CITY OF ALBUQUERQUE

October 15, 2021

**RE: Home 2 Suites Hotel
3021 University Blvd SE
Grading and Drainage Plan
Engineer's Stamp Date: 03/23/20
Hydrology File: M15D047**

Based upon the information provided in your submittal received 10/07/2021, the Grading & Drainage Plan **is not** approved for Building Permit, Grading Permit, and Foundation Permit. The following comments need to be addressed for approval of the above referenced project:

GRADING & DRAINAGE PLAN

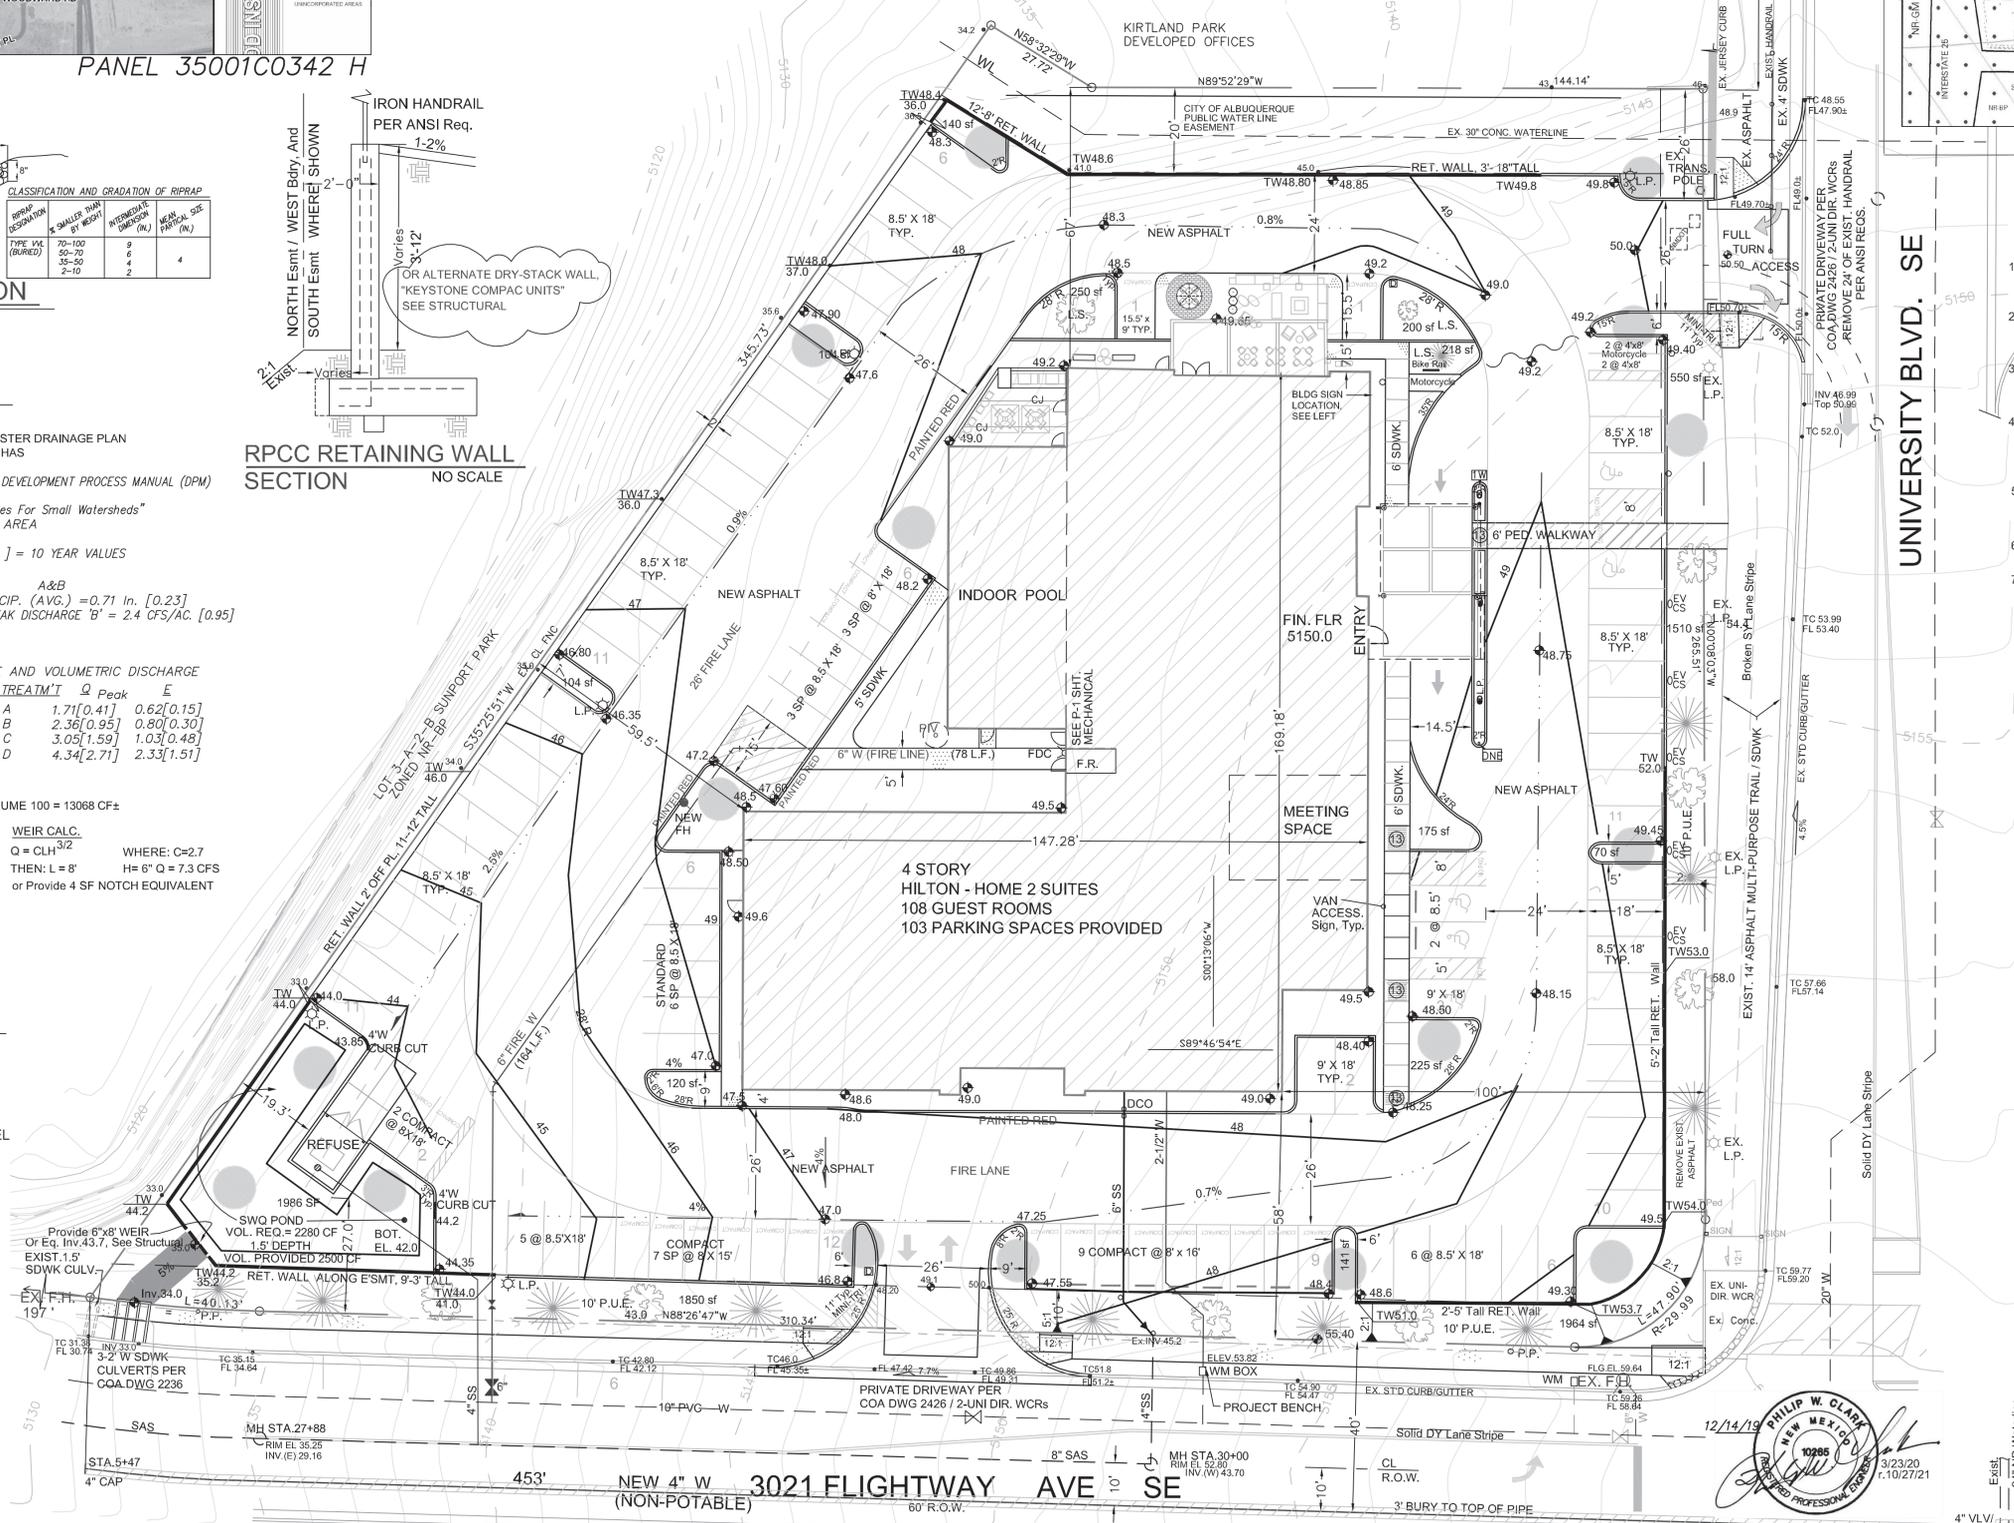
1. Under the Existing Conditions, please make reference that this site is part of the Sunport Phase 1 Master Drainage Plan by Andrews, Asbury & Robert, Inc dated 1996 and has free discharge into Flightway Ave.

2. Please remove the section Historical Conditions.
3. Please update the reference to the new Development Process Manual (DPM) (signed 06/08/20) Chapter 6 is Hydrology.

4. Please update all calculations per Article 6.2 of the DPM. The runoff numbers will be less than the old DPM.
5. Please update stormwater quality calculations per Article 6.12 of the DPM. The required volume will be greater than the old DPM. If the volume cannot be achieved, then a payment-in-lieu for the difference can be done at \$8/CF. If this is the route, then just add a line under the calculations stating, "The Owner has elected to handle the difference of xx CF with payment-in-lieu of the amount \$xxx".

6. Please add these flowline points at each driveway to ensure that the required waterblock per CoA drawing 2426 is provided. See images below.

7. Please remove the existing inlet in the proposed drive on University Blvd and install a new inlet at the tangent of the curb return. Storm Maintenance does allow a bend in the storm pipe if it is within 5 feet of the proposed inlet. This may be the case. However if this cannot be achieved, than a new manhole will have to be installed on the existing 18" RCP as shown below. I have also attached some existing utilities within University Blvd that I could locate for your use. These may need to be shown. This inlet and maybe manhole will need to be added to the approved Infrastructure List. So this will have to be changed at the Development Review Board (DRB).
